CITY OF ALBUQUERQUE

**Re: Garcias Kitchen Food Prep & Catering
Grading and Drainage Plan
Engineer's Stamp Date 10/23/2012 (J13/D096)**

GRADING AND DRAINAGE PLAN

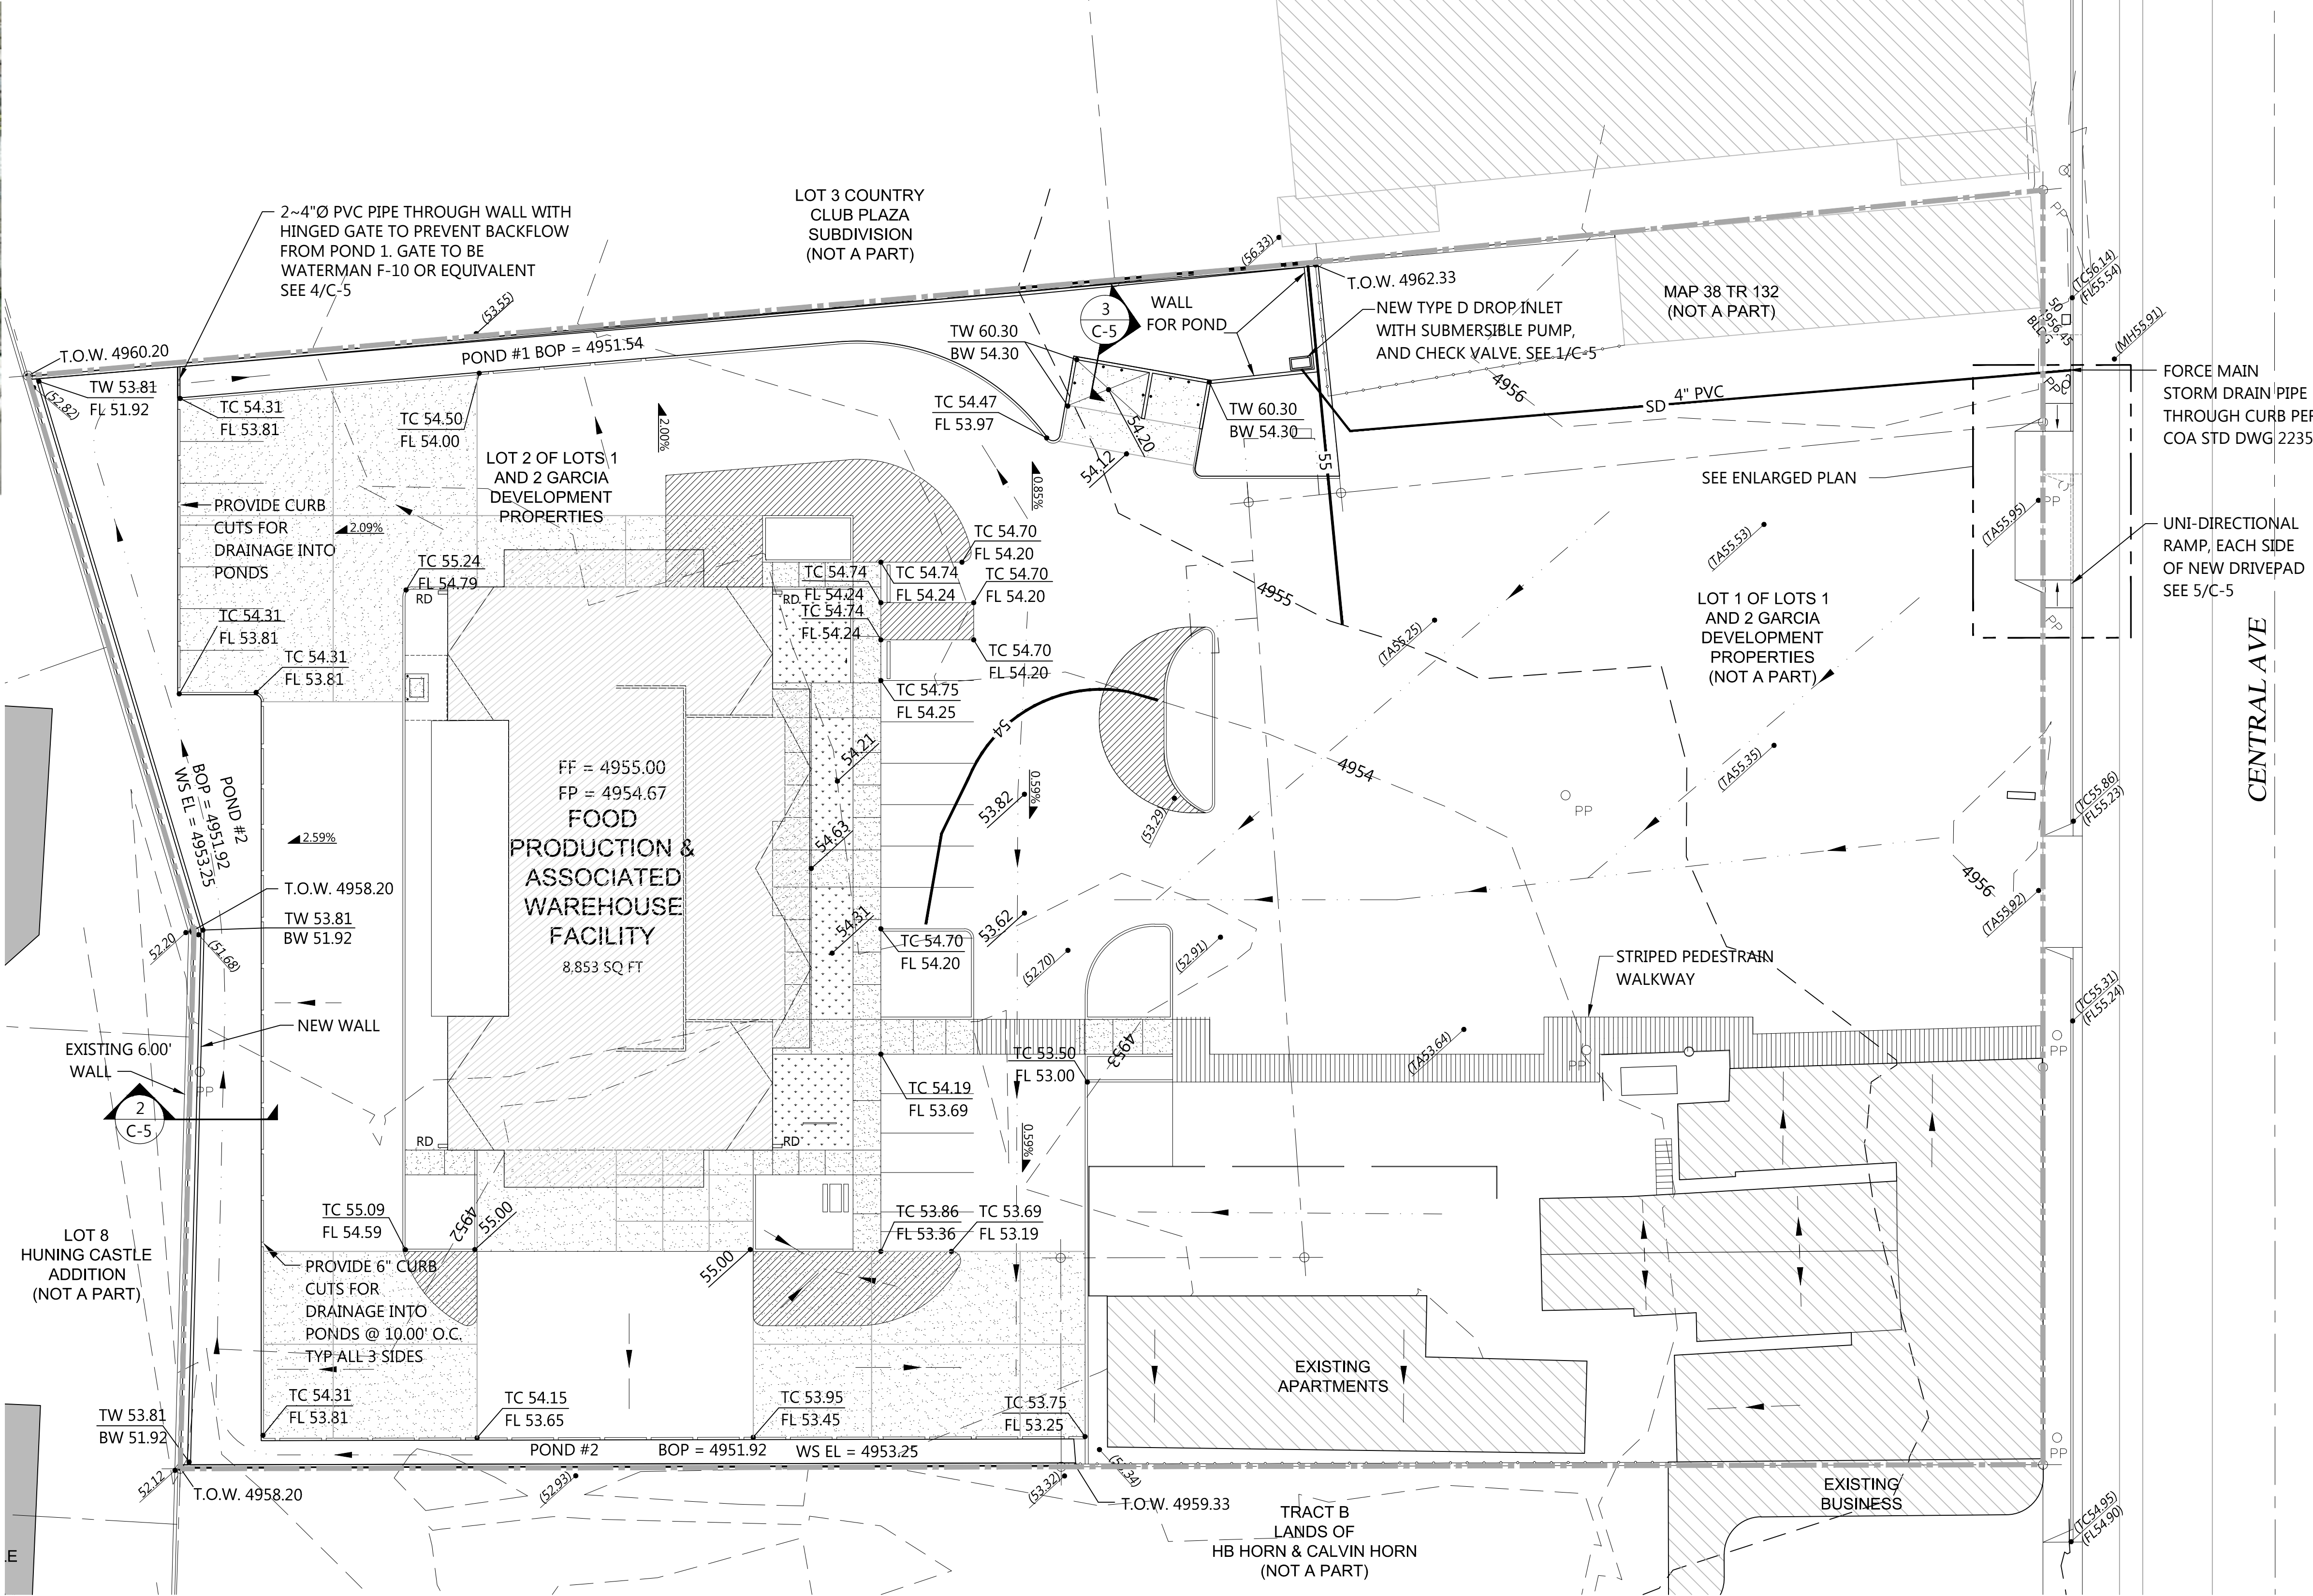
- Please quantify the flows entering from the north.
- Provide spot elevations abutting the site.
- Provide pond calculations.
- Provide pond over flow locations.
- Label Central Ave.
- Per the DPM Chapter 22 Section 9, runoff from the trash enclosure pad is required to drain to the sanitary sewer.
